Your reference: SSD 5348
 Our reference: ECM 4396078
 Contact: Robert Craig
 Telephone: (02) 4732 7593

4 November 2013

State Significant Development Application for Stage 3A Subdivision of North Penrith Defence Site (SSD-5348)

Section 1

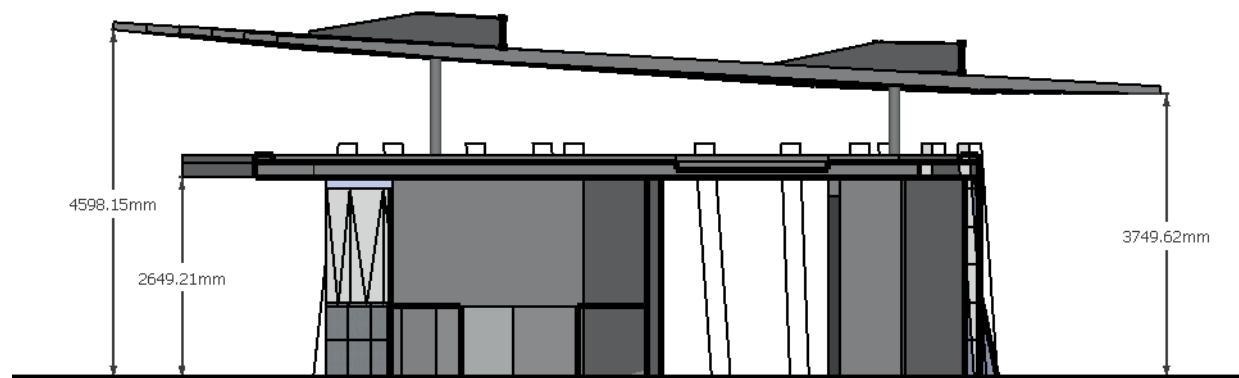
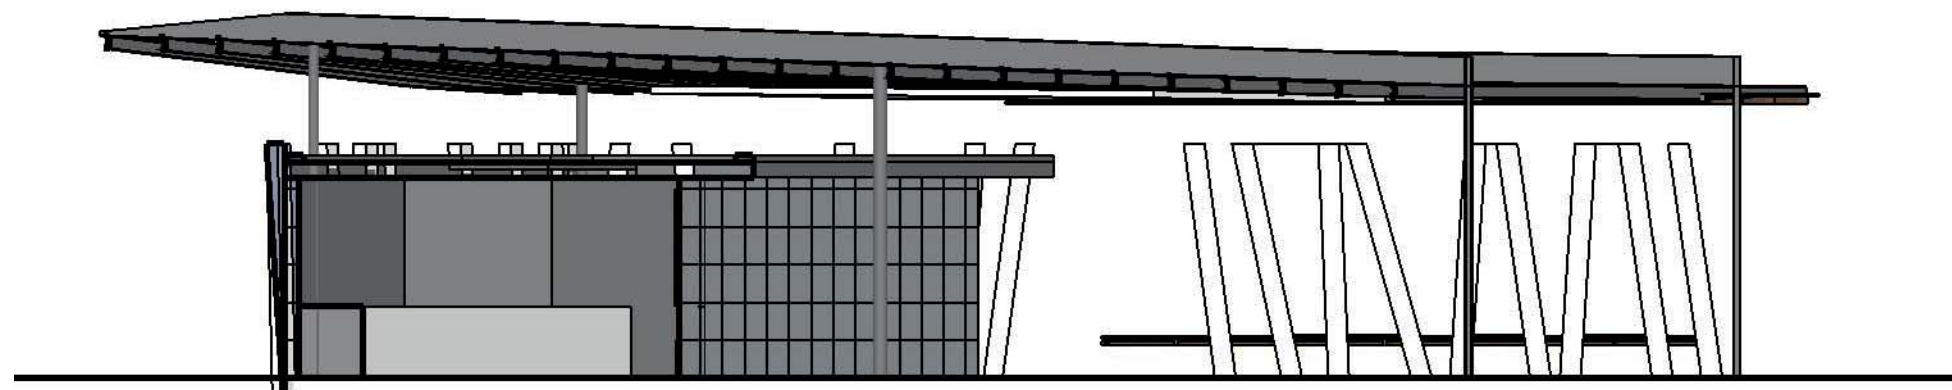
- The kiosk building (including toilets) shall be well lit with sturdy under-awning lighting provided to achieve lighting levels in accordance with relevant Australian Standards. Internal lighting shall also be provided.

- The toilet facilities shall be fitted with sturdy locks so that they can be securely locked after hours and to prevent opportunities for malicious damage. Stainless steel fixtures are recommended. MLAK locks shall be fitted to the accessible toilet to enable access only for persons with a disability.

- Toilet cubicle doors shall be fitted to remain open when not in use so that people can clearly observe the cubicle prior to entry and vice versa. These design principles have been applied in Council's own Public Toilet Replacement Program and promote safer use of public amenities.
